Recommendation Report for Planning Permission

REF NO: R/230/19/PL

LOCATION: Springfield House
Springfield Close
Rustington
BN16 2SZ

PROPOSAL: 1 No. dwelling and swimming pool (part resubmission following R/91/17/PL & R/204/18/PL).

Job Title	Springfield House		
Client	Castle Property Developments		
Drawing Name	Garage - Plan & Elevations		
Drawing Status	Planning		
Drawn by	DF	Date	Sept 19
Checked by		Date	
Drawing Scale	1:50 & 1:100 at A1		
Drawing No	Status	Revision	
181303/	09

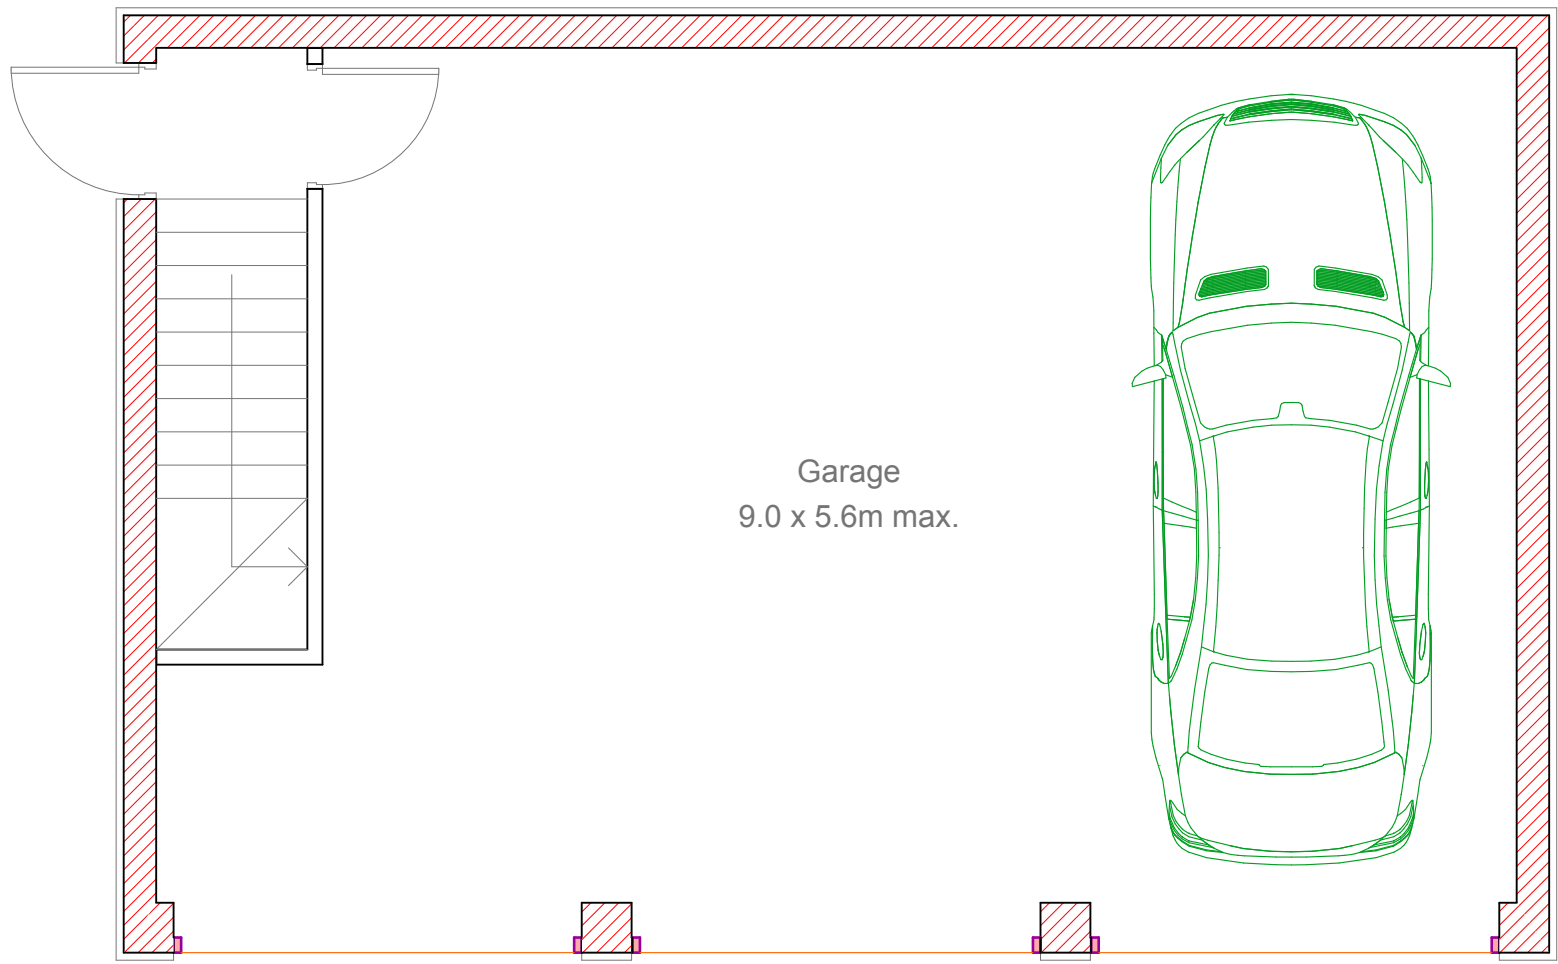
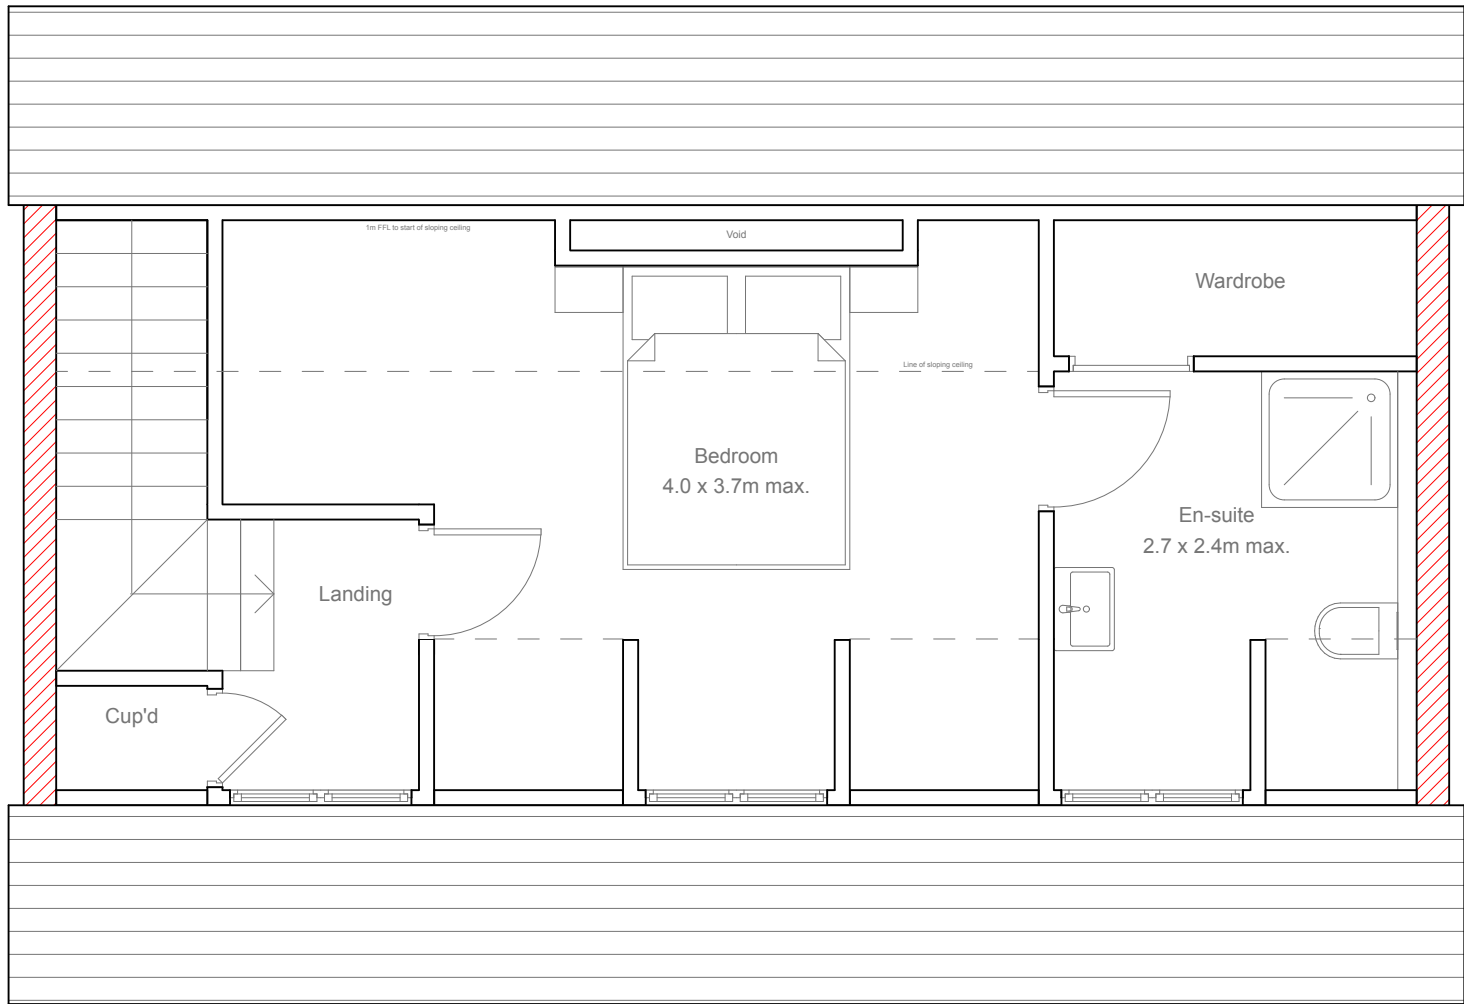
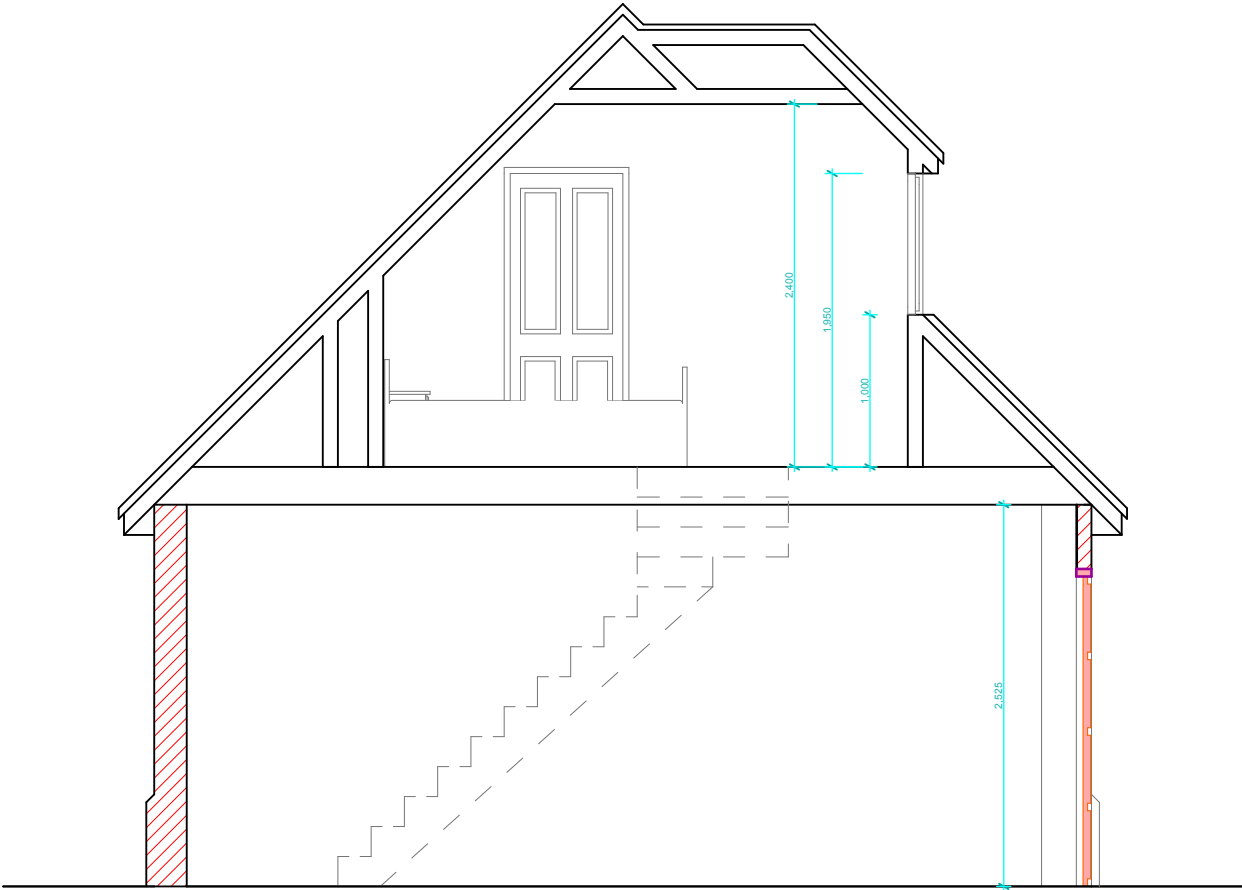
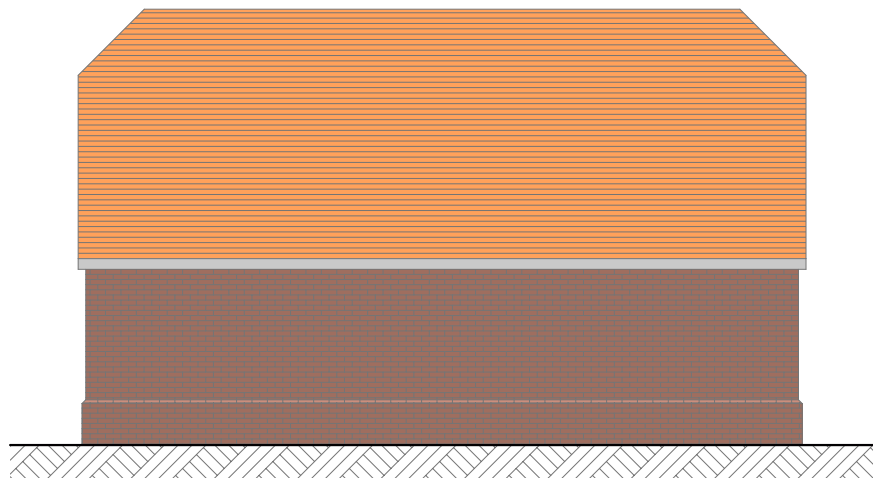
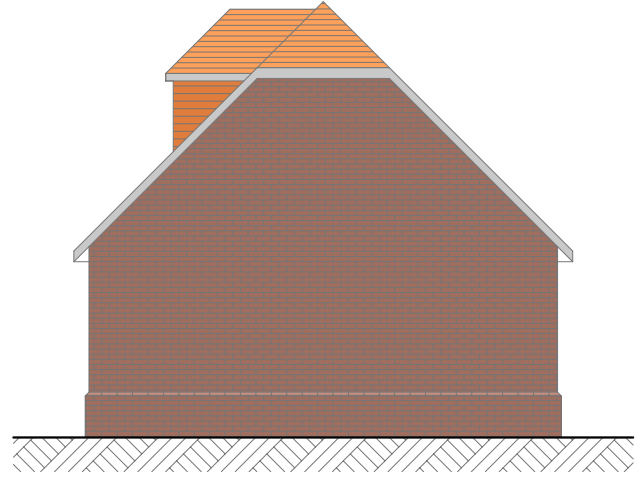
- First Floor accommodation on triple garage block will directly overlook neighbouring garden and would be overbearing.
- New house is large enough. Provision of triple garage in corner of site close to boundaries would appear cramped and out of keeping.

The concerns relating to the garage in respect of its proximity to the boundary and overlooking from the first floor are shared. This element of the proposal has been deleted from the application.
